Regulatory, Planning and Assessment.MBisson/GMansfield
Reference: PB2020/03154
Phone: 02 4974 2000

24 April 2020

MIXED USE DEVELOPMENT (SSD 10378) 42 HONEYSUCKLE DRIVE NEWCASTLE

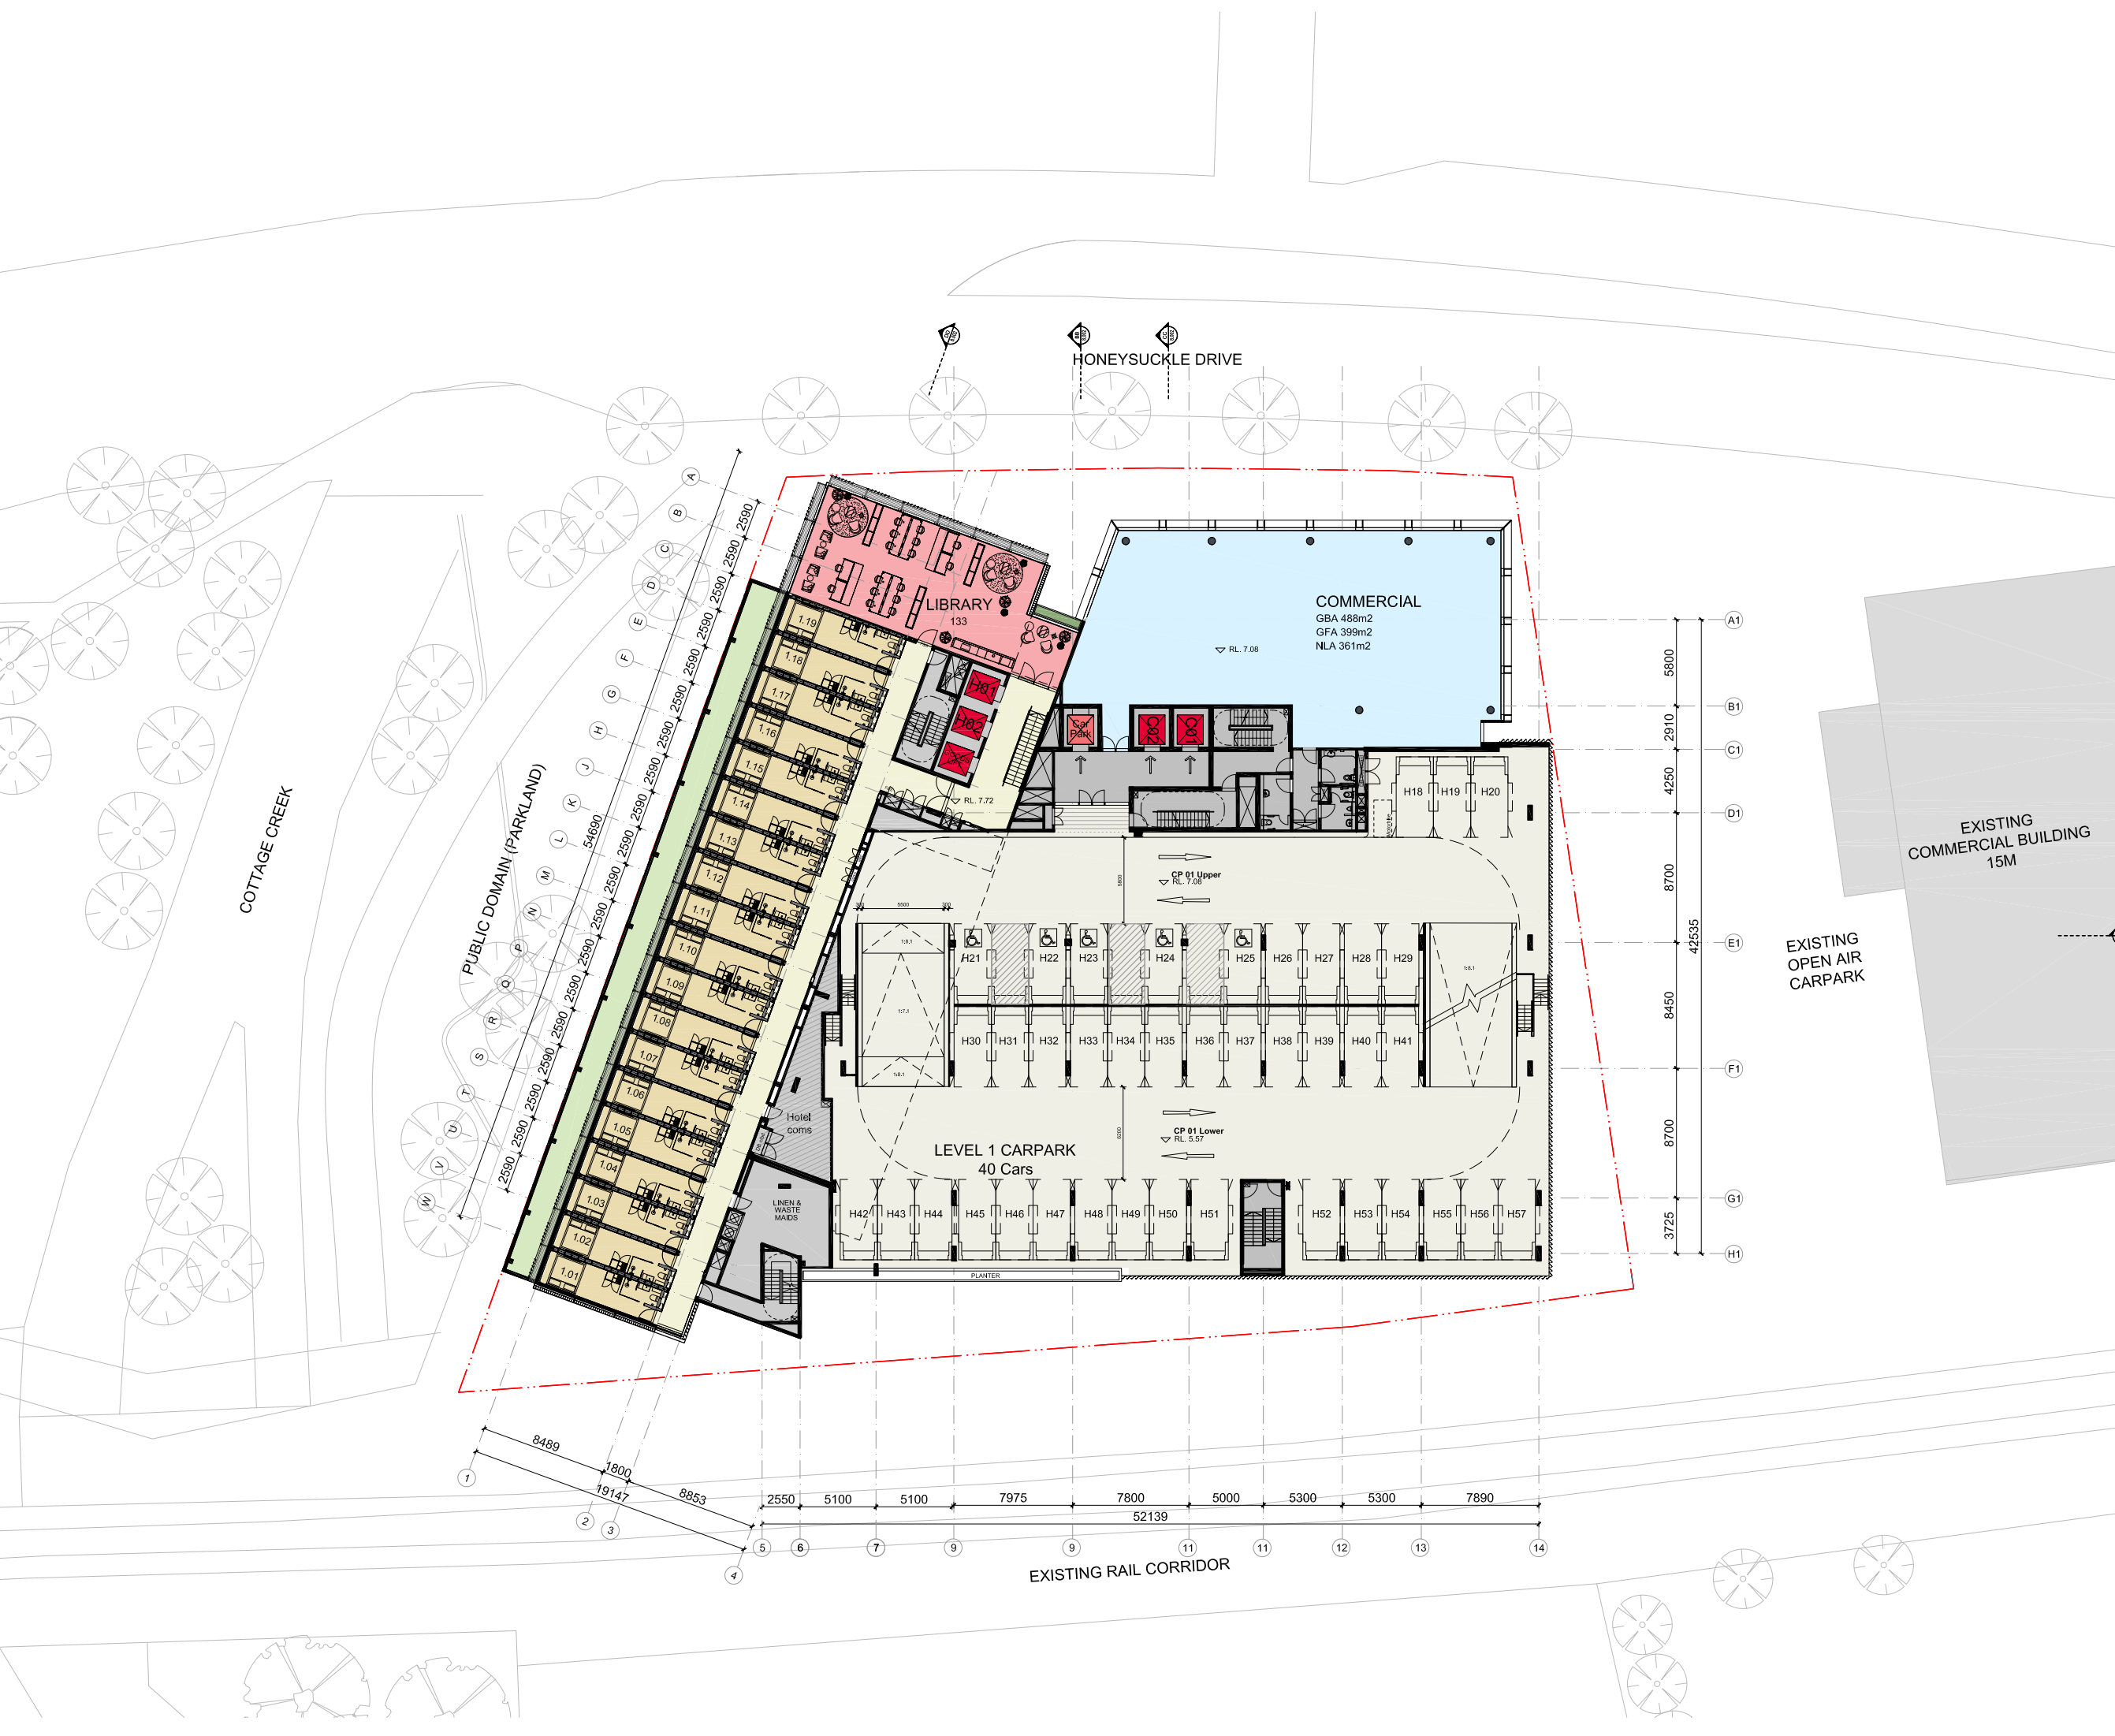
The Newcastle Development Control Plan (NDCP) 2012 provides that parking for developments, other than residential in the City Centre, are calculated based on a 'flat' parking rate of 1 space per 60m² of Gross Floor (GFA) area. Based on a GFA of 12,510m² and the above parking rate the development requires 209 spaces. The submitted plans provide a total of 173 spaces, and therefore equates to a deficiency of 36 spaces.

Given the above circumstances, it is considered that the EIS has not satisfactorily justified the variation from the above City Centre parking rate and it is recommended the applicant amend the design to ensure satisfactory compliance with the requirements of the NDCP.
